Application No: AB/82/20/L

Site Address: 83 Tarrant Street Arundel BN18 9DN

Description of works: Listed Building consent to split bathroom into 2 to form en-suite and separate shower room, alter position of front en-suite shower room, change ground floor kitchen in to bedroom with en-suite, reconfigure staircase leading to basement & improve headroom, reduce level of floor slab to increase headroom & convert garage & storage area within basement into habitable accommodation to form open plan kitchen & living room with separate WC and games room, infill garage door opening with full height glazed doors, changes to fenestration, form external light well to front and replacement of existing windows to front and rear.

DRW NO 9 SCALE 1/10 (A3)
EXISTING REAR WINDOWS
ELEVATION / SECTION.

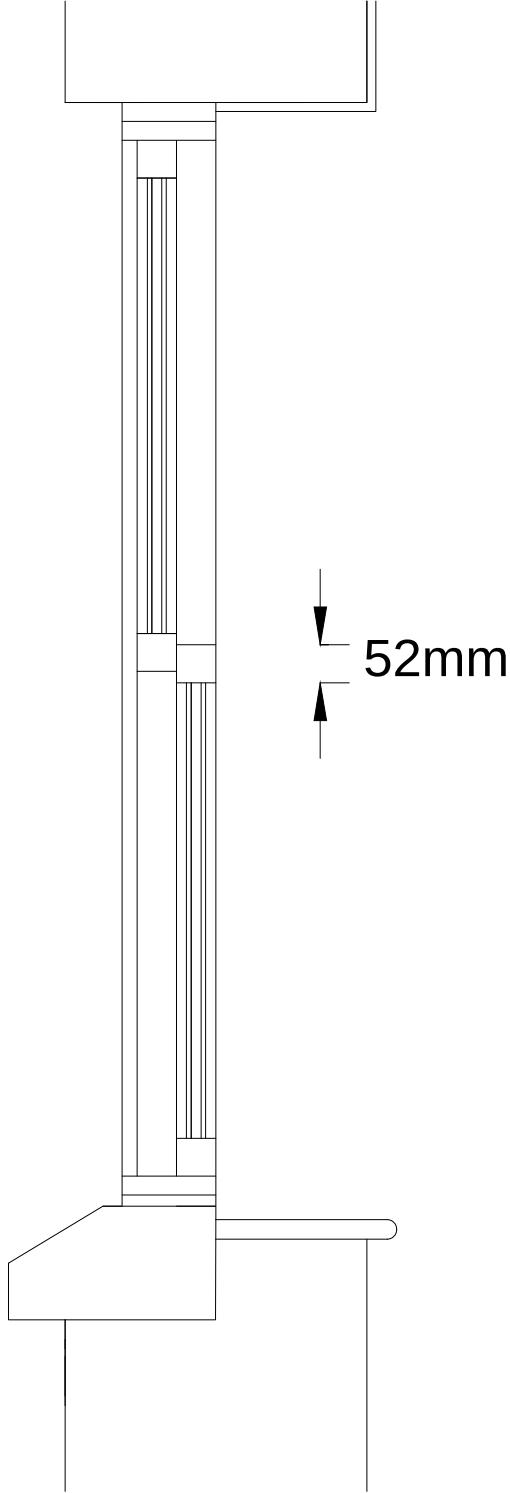
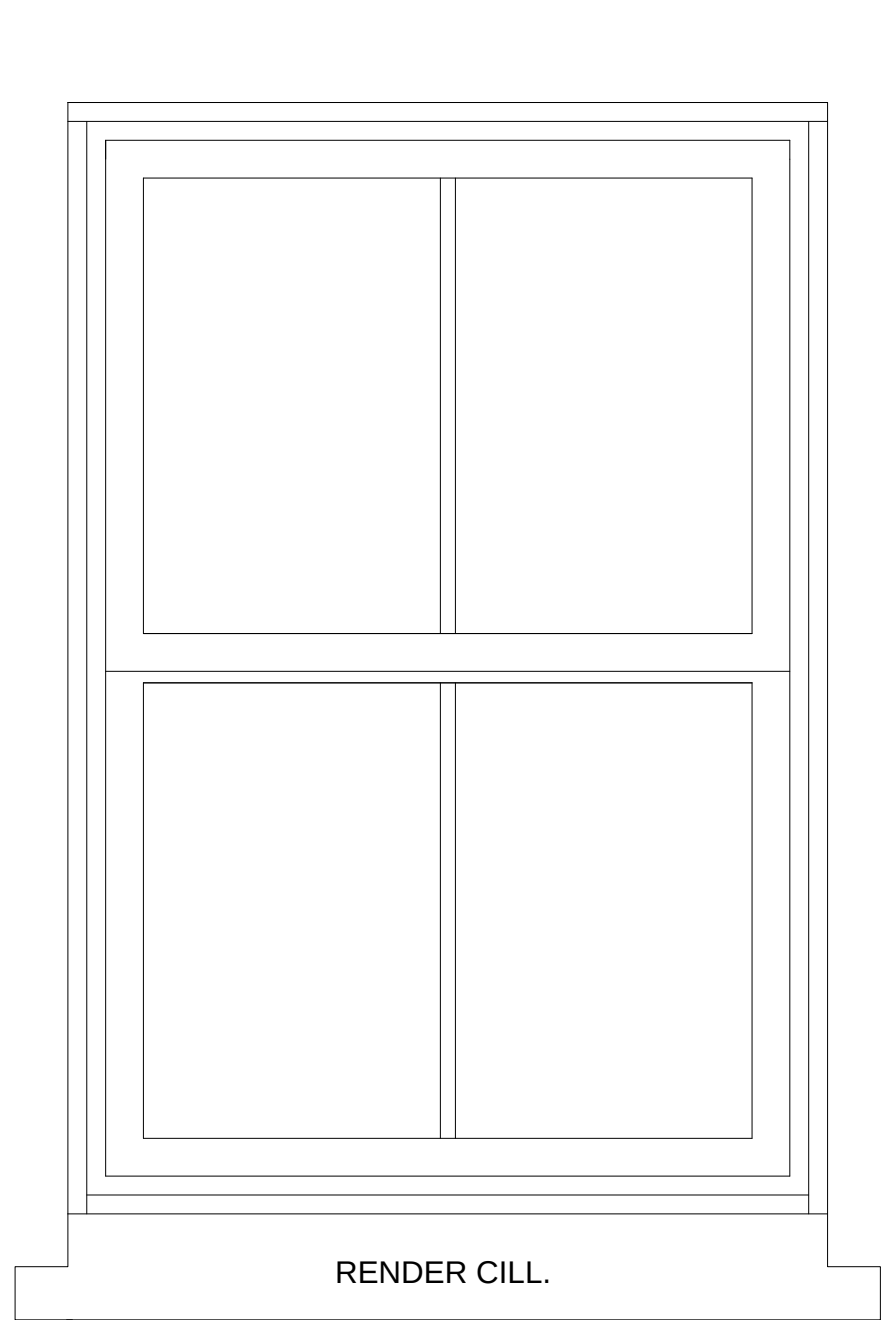
The change from aluminium windows to timber vertically sliding sash windows on the rear elevation will result in an improvement to the external appearance of the building and, thereby, that of the conservation area.
